From: Contact Centre (CRM) <contact@ribblevalley.gov.uk>
Sent: 13 August 2026 13:06
To: Planning
Subject: Planning Application Comments - 3/2026/0488 FS-Case-865196009

Planning Application Reference No.: 3/2026/0488

Address of Development: land to the rear of The Nook, Snodworth Road, Langho, BB6 8DR

I wish to object strongly to planning application 3/2026/0488 for the erection of six dwellings and associated access and landscaping on land to the rear of The Nook, Snodworth Road, Langho.

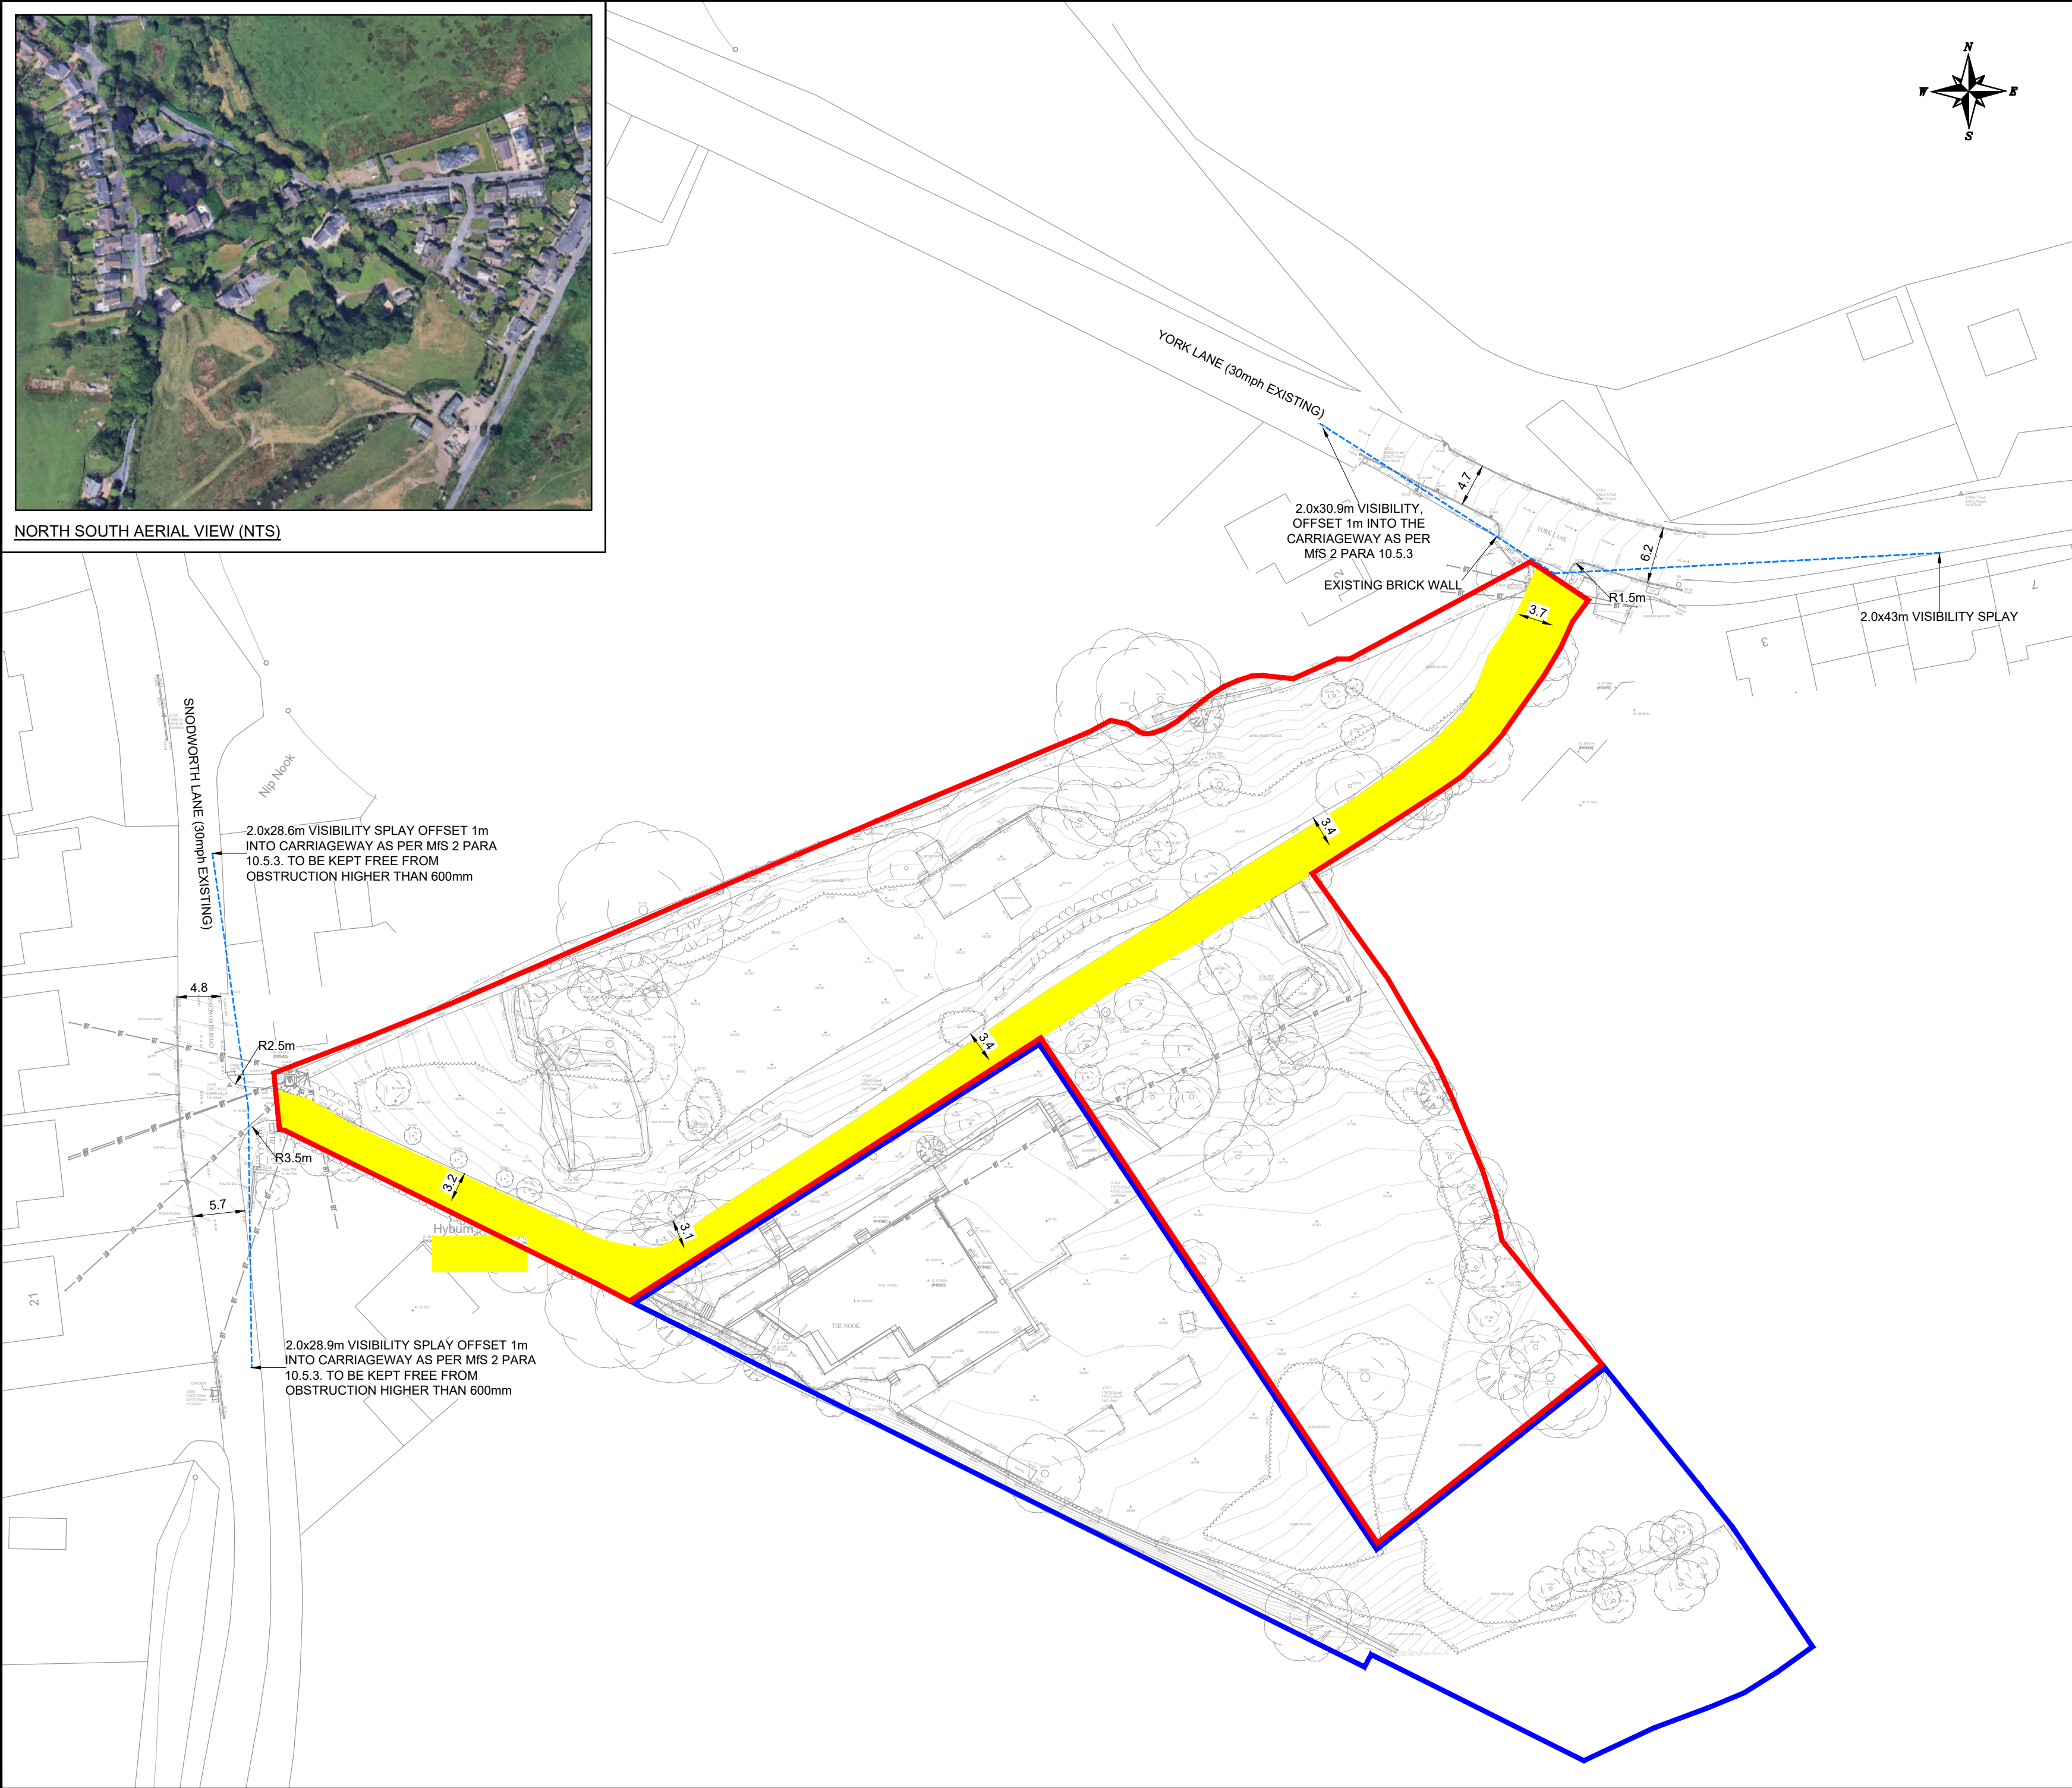
The applicant's own Transport Note acknowledges that the existing visibility available at the Snodworth Road access is below the visibility normally required for a new junction on a 30mph road.

The Transport Note identifies visibility of approximately 2m x 28.6m northbound and 2m x 28.9m southbound. It also acknowledges that this is below the normal requirement for a new junction.

That is not sufficient to demonstrate that the proposed intensification is safe.

The issue is not simply whether the existing single dwelling can use the access safely. The proposal would increase and intensify vehicular movements associated with additional houses, residents, visitors, deliveries, refuse collection and servicing.

The absence of a recorded accident history does not demonstrate that a junction with restricted visibility is appropriate for a materially intensified residential use.
